**Ann Machado - Fwd: Form For Carter Revisions**

Rachel has asked me to forward a few documents to you for the Carter Residence permit application, which is currently on your desks for review.

Please find attached an Administration Authorization form, and revised and stamped pages A1 and A2 from the permit drawing set.

A1

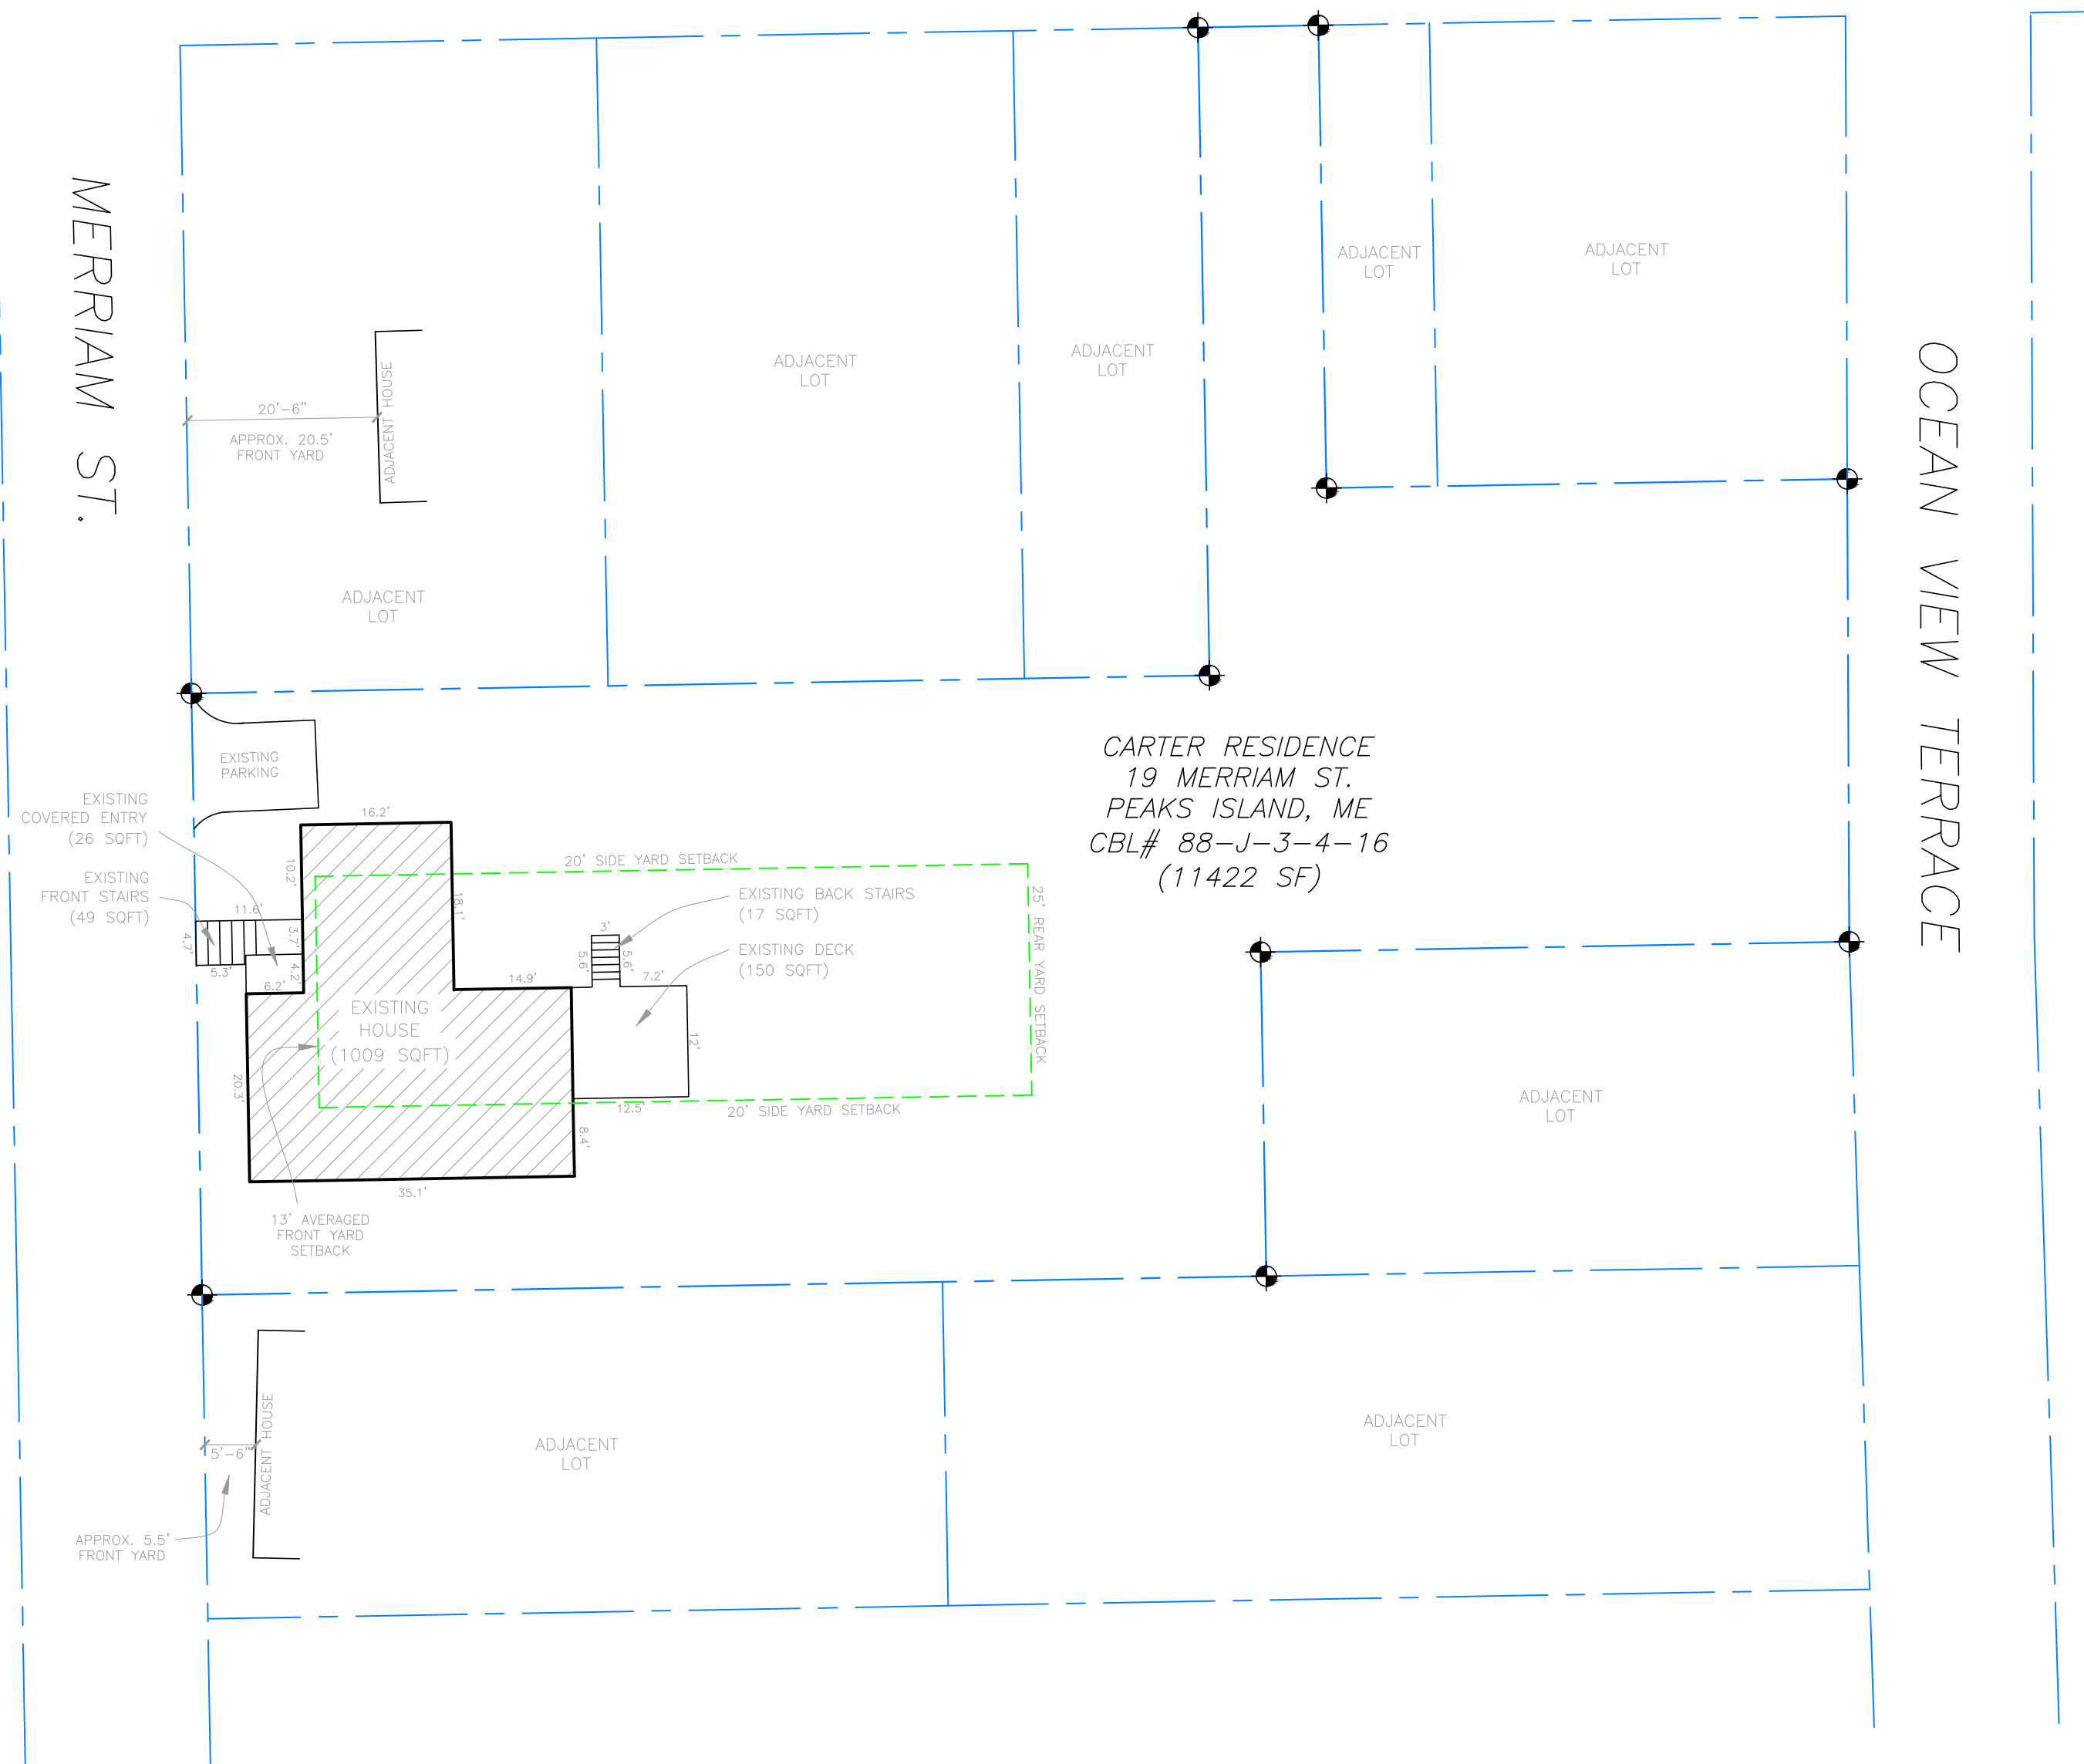
Are any of the details on A-3 thru A-5 that are not on the modular plans? If not then I guess you can delete them. We do need the site plan stamped by a design professional. A surveyor is fine.  
Ann

A2

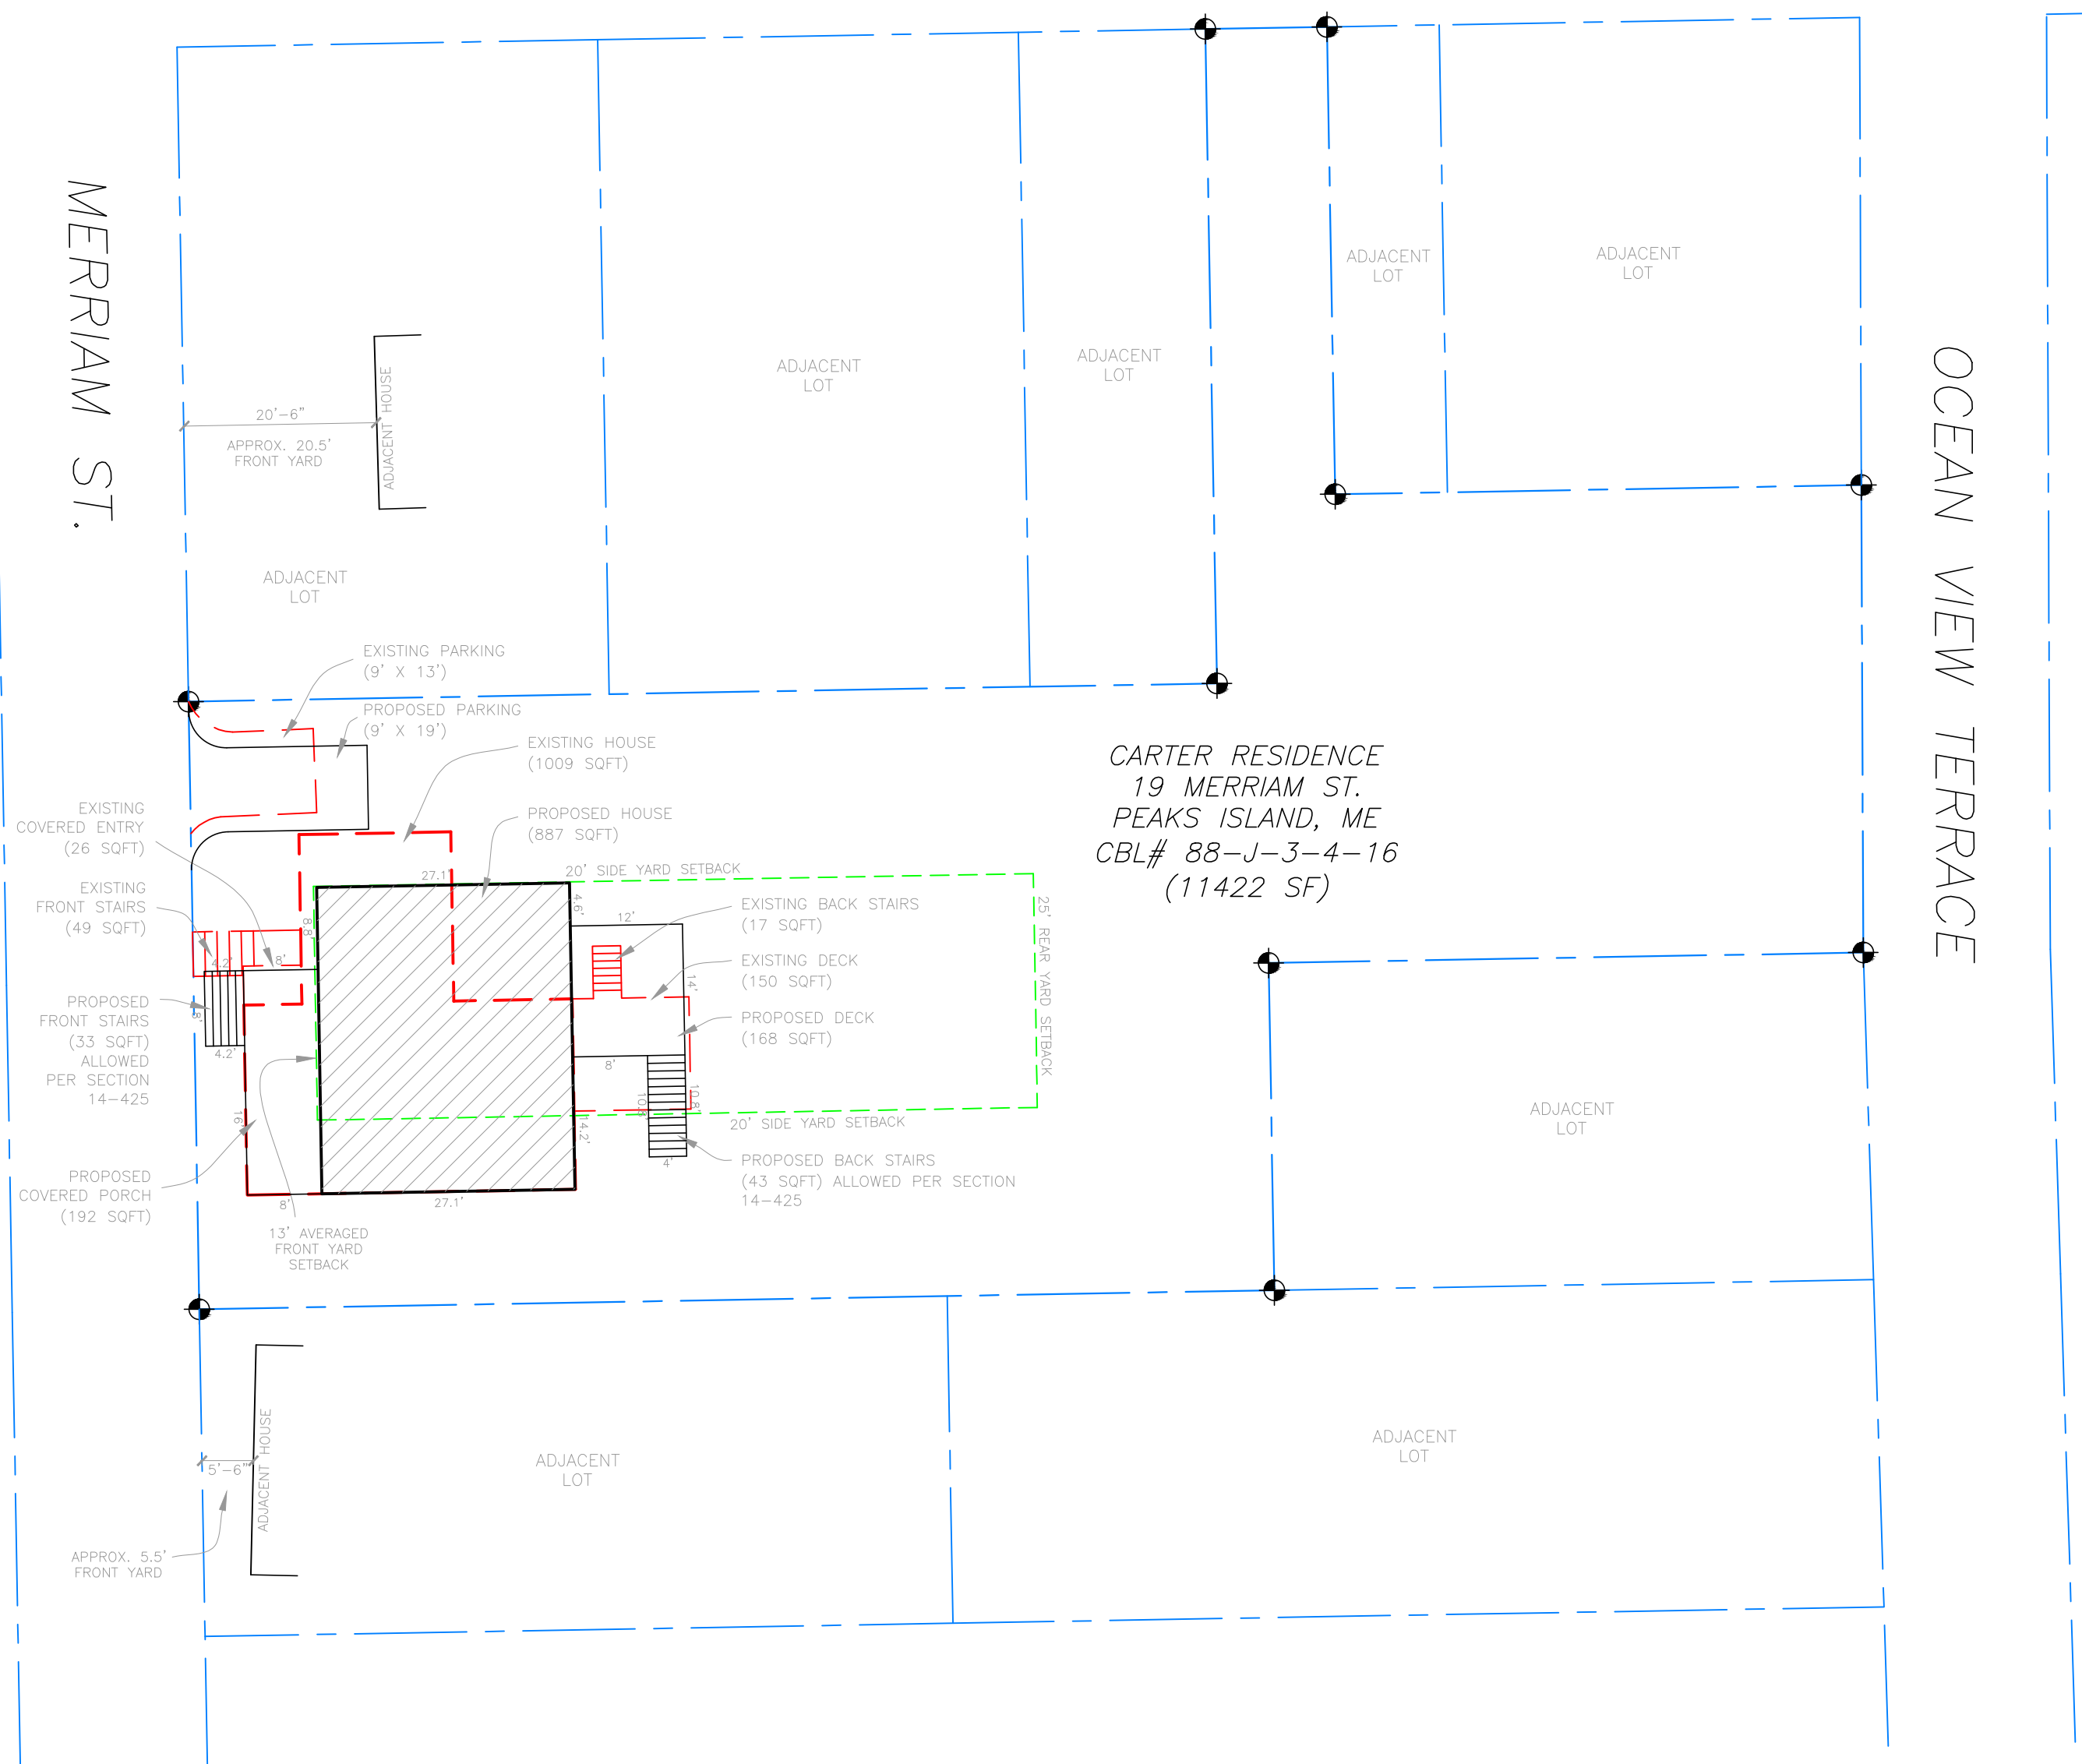
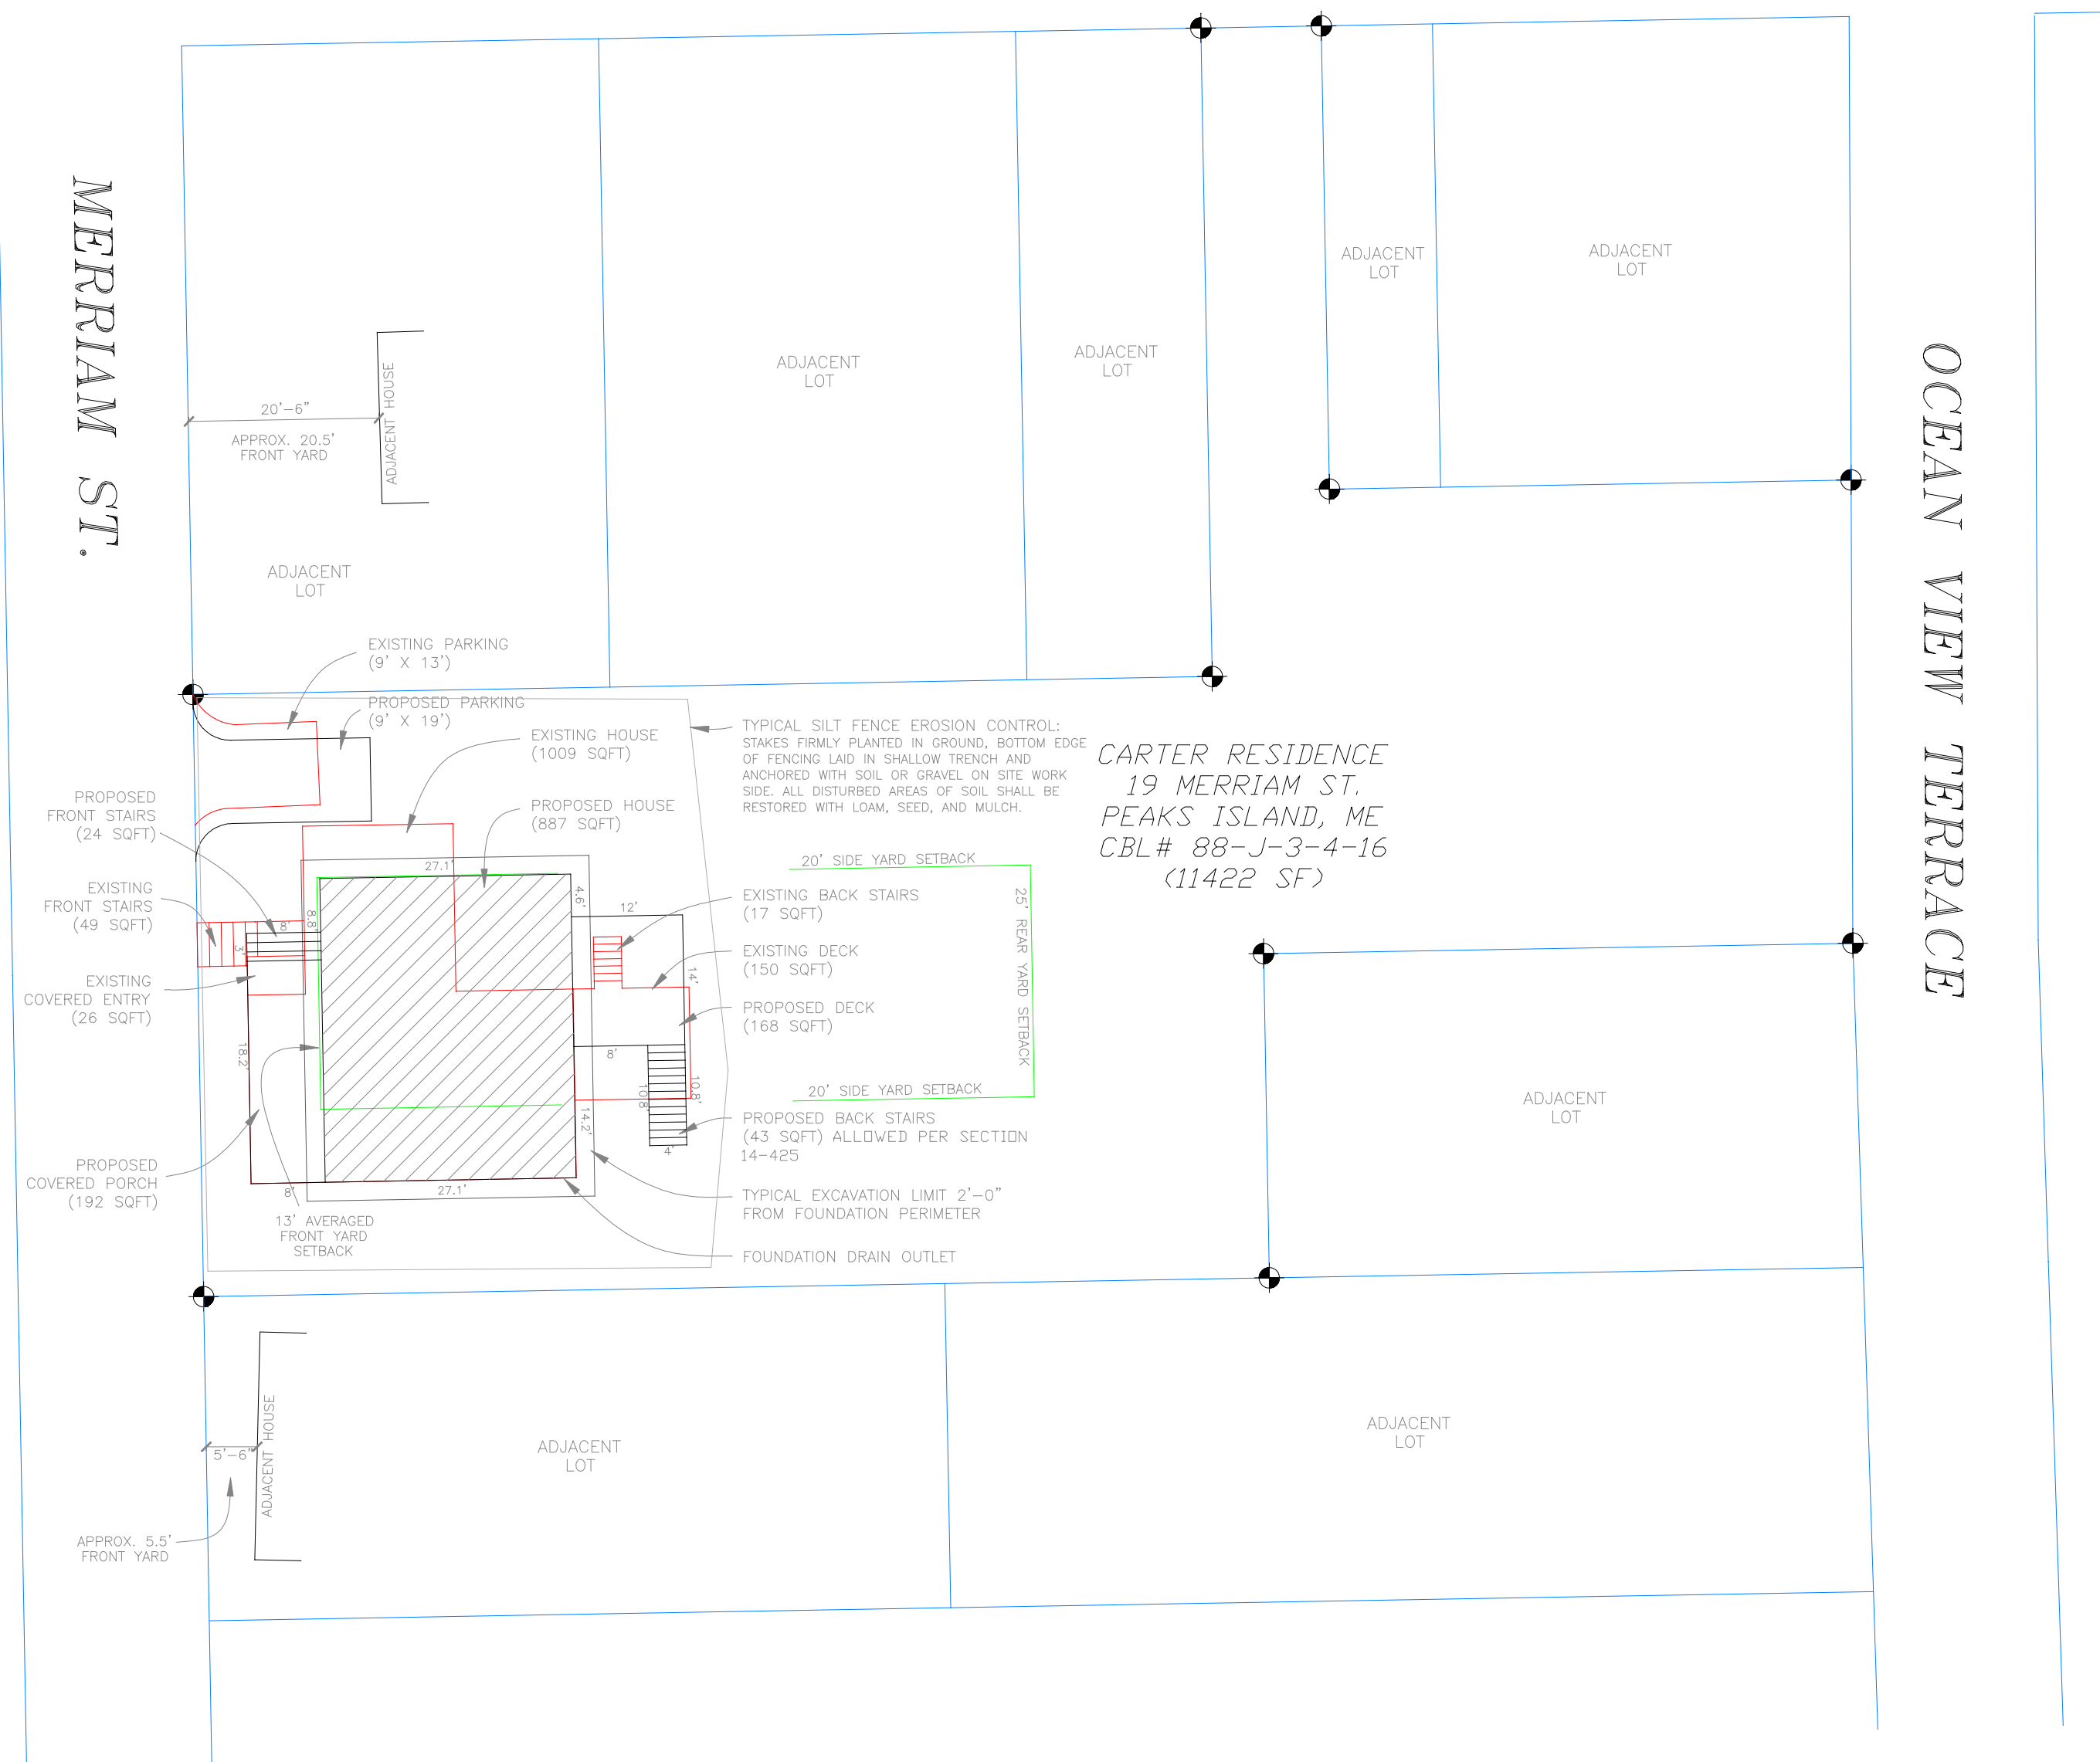
1. The architectural plans A-1 thru a-5 are not stamped by a design professional.
2. You need to reduce the footprint of the front steps. Section 14-425 does not work because the under this section the entry porch cannot extend more than 6 feet off the building. There is already a covered porch extending 8 feet off the building in the footprint of the old house. The footprint of the new stairs needs to match the part of the footprint of the old stairs that extend towards the street beyond the existing footprint - 5.3' x 4.7' = 24.91 sf. Maybe you can reduce the width of the proposed stairs.

A2: As requested, we changed the front entrance stairs so that they remain within the existing footprint. We also added notes about drainage and erosion control.
